**Consultation Response from KC,
Trees**

2026/90926 3, Lower Rotcher, Rotcher Lane, Slaithwaite, Huddersfield, HD7 5AZ

Erection of two storey and first floor side extensions and formation of parking area with associated works

Date Responded: 29/04/2026

Block plan (1:500)

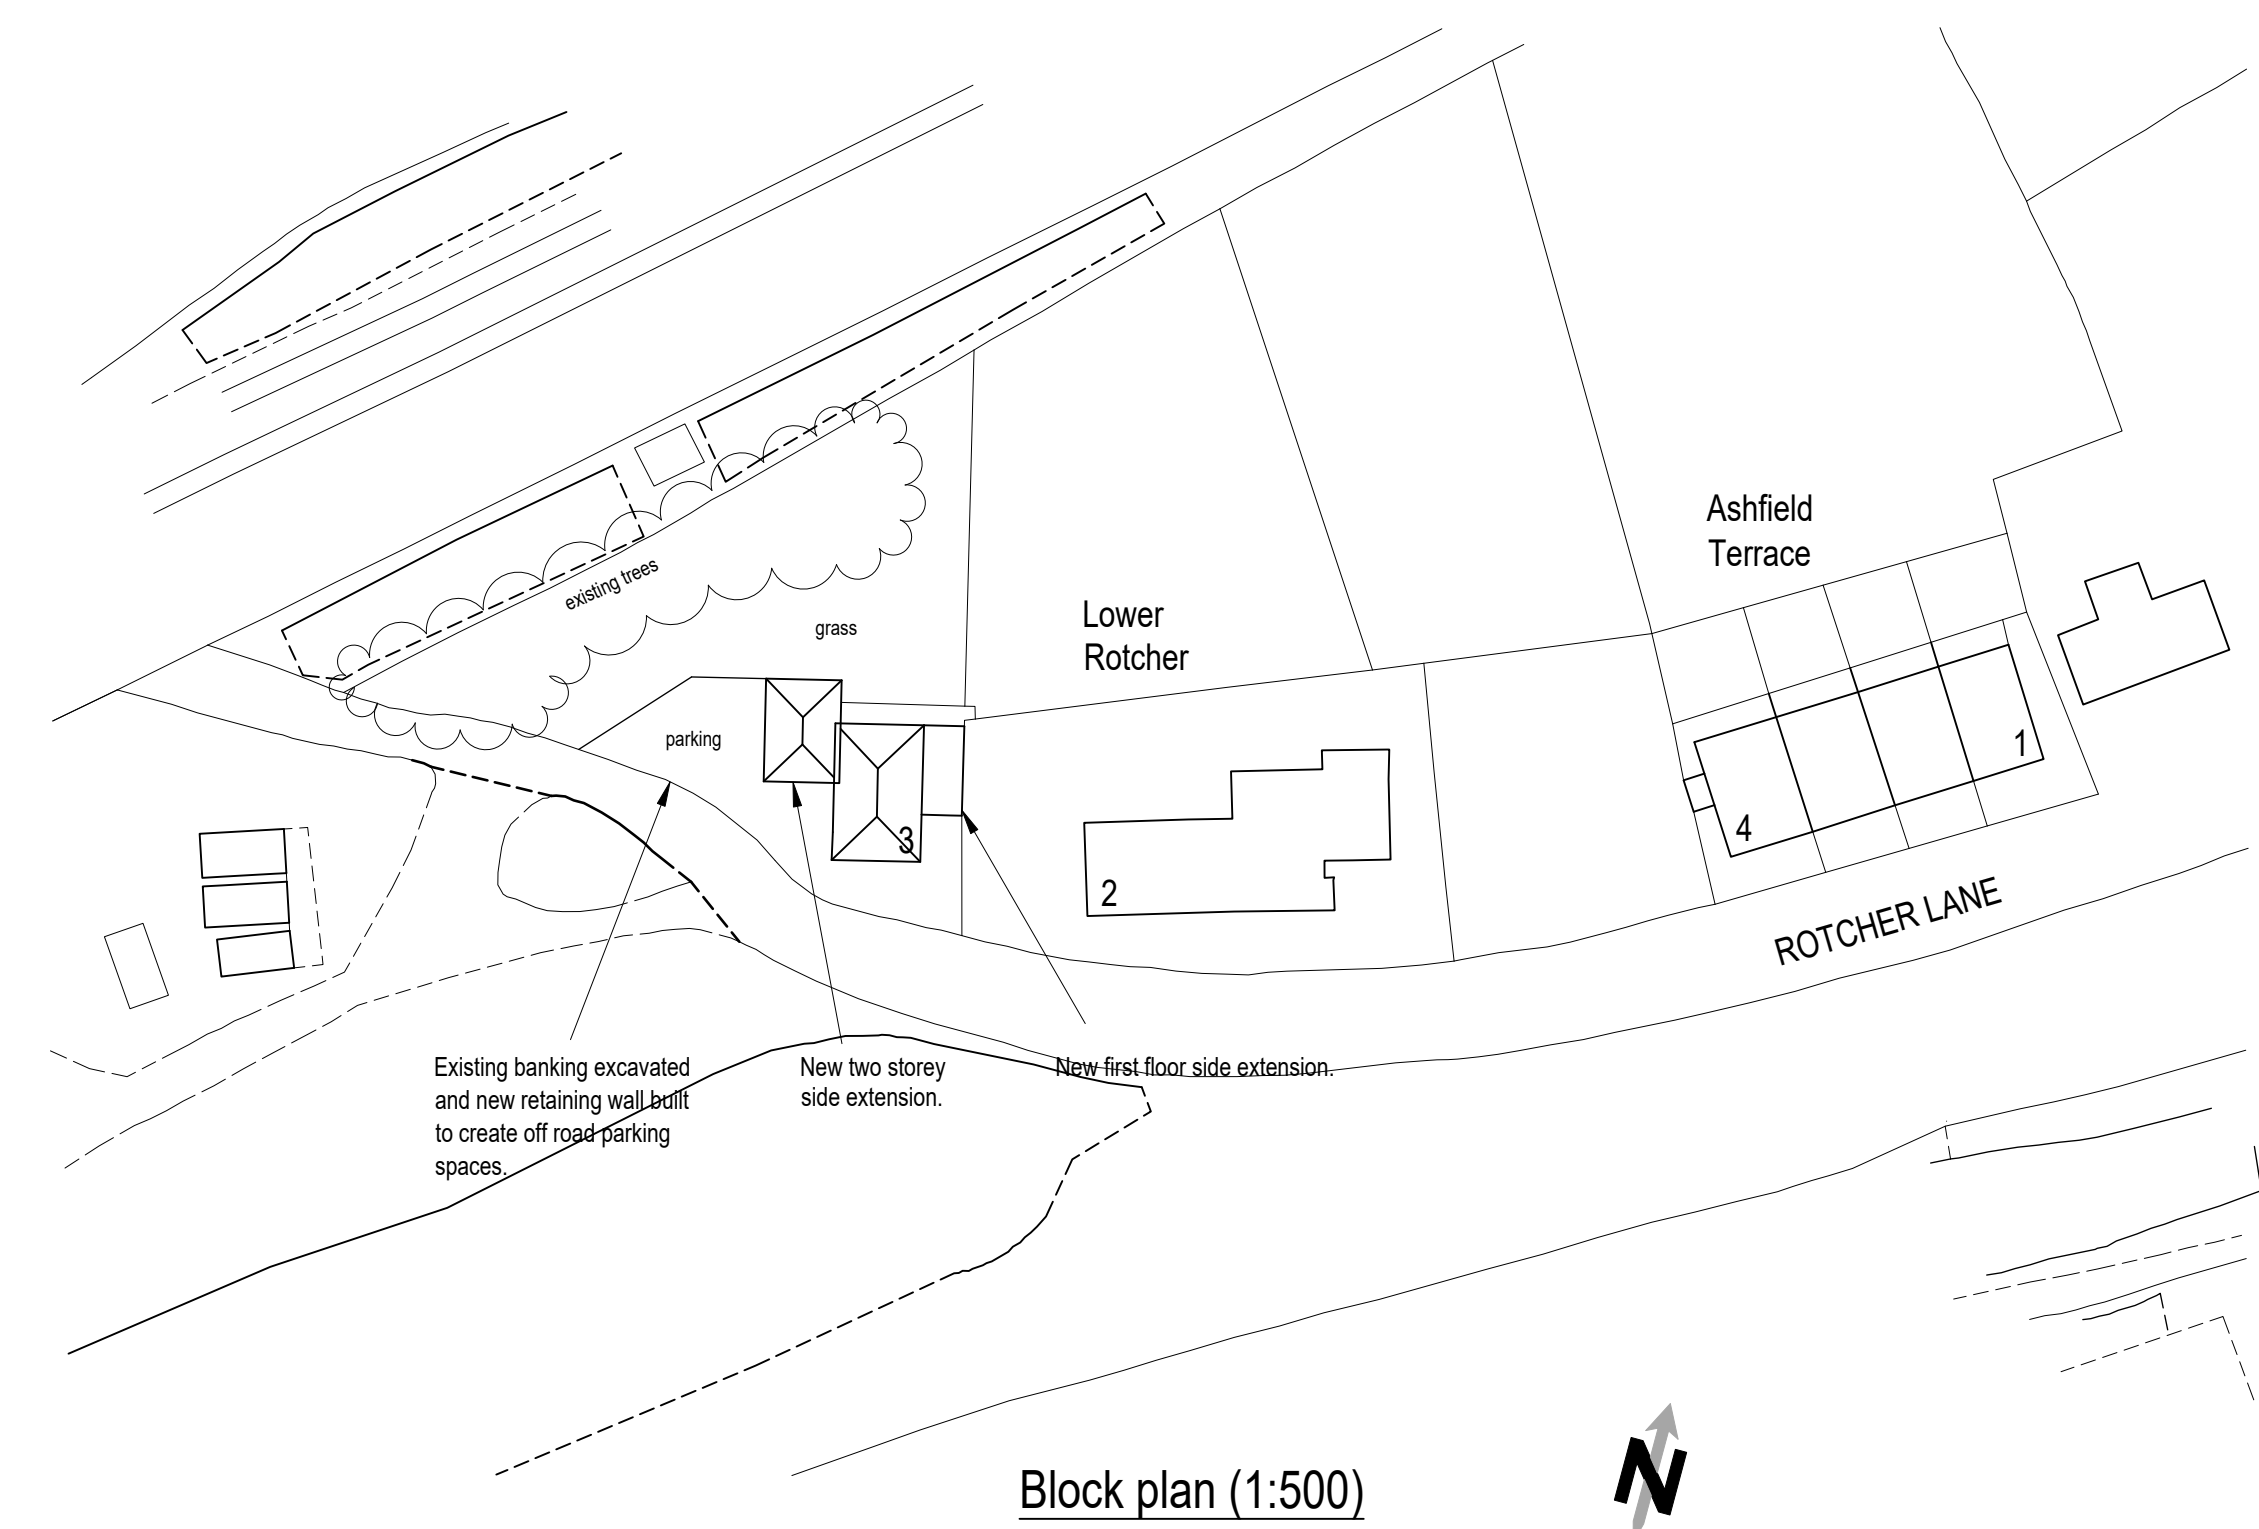
The proposed development would require several coniferous specimens to be removed to the frontage of the property. This would generally be acceptable due to the condition of these trees and them having a relatively low amenity value. None of the trees on this site are protected.

With these trees removed the proposals look achievable whilst staying outside of the root protection area's of the higher value deciduous trees to the rear boundary.
